**Section 75W Modification Application, Sydney Superyacht Marina
(MP09_0165MOD1)**

Previous responses to the original DA and PAC consideration/process

1 Cross Section - WEST BLOCK A-A
1 : 200

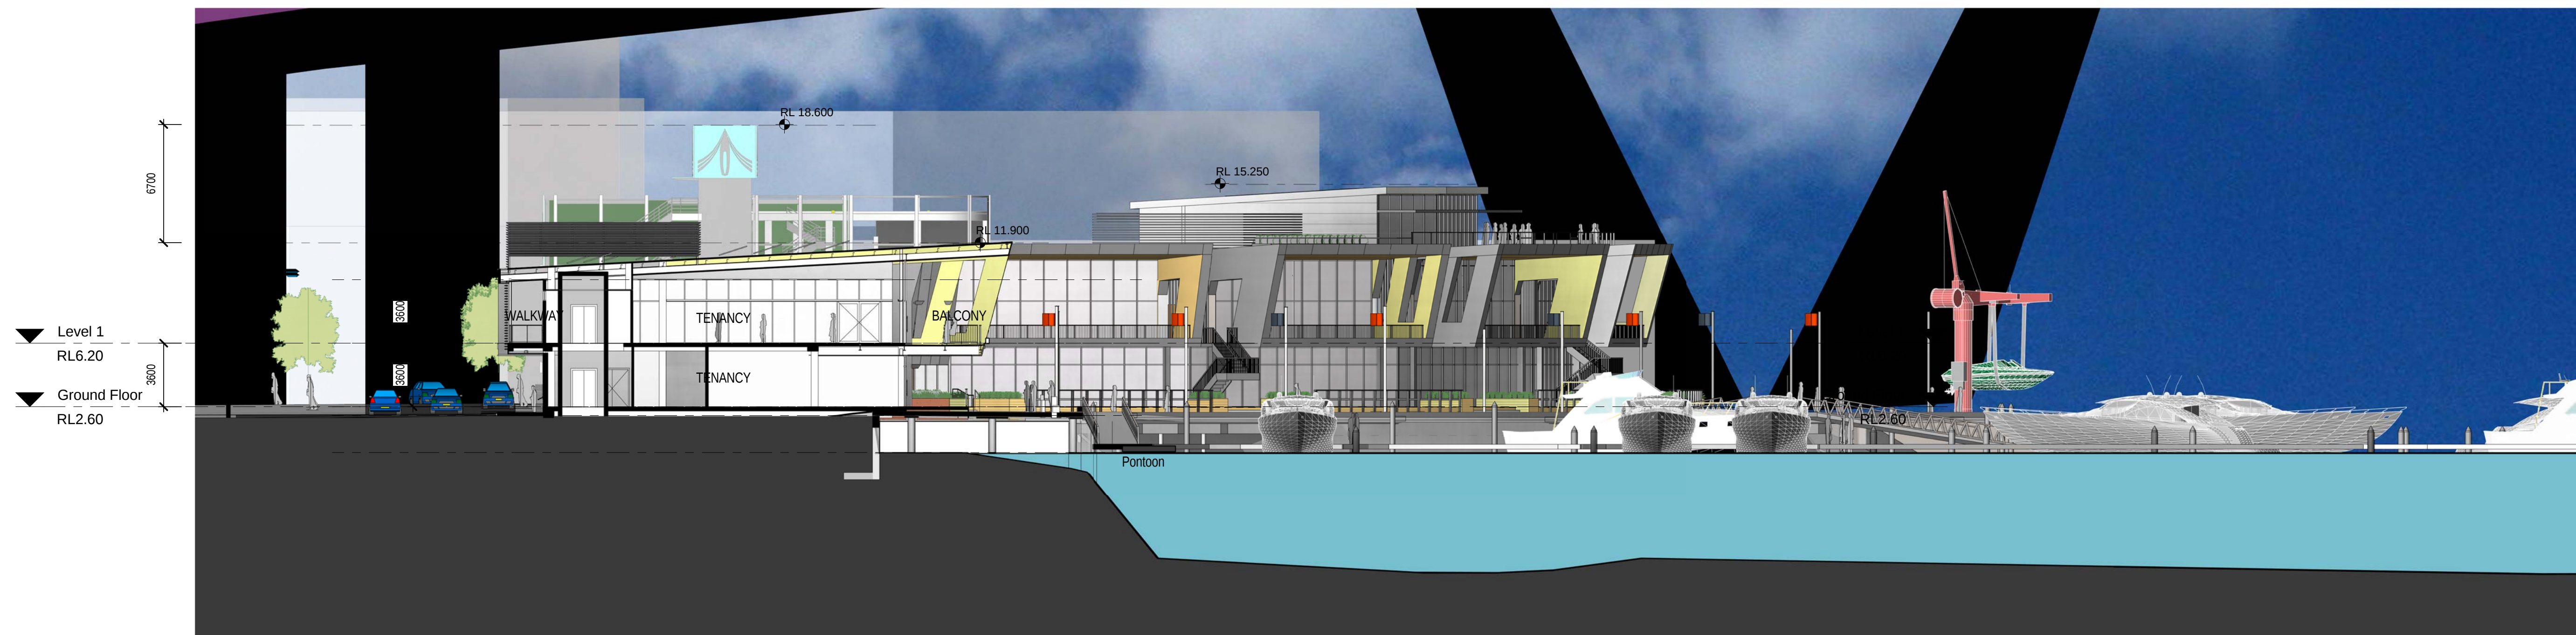
3. **New design elements in modification exacerbate and encourage noise impacts** – The additional roof level and terrace, and use of outdoor seating will exacerbate the noise generating potential; of the development over that approved to date.
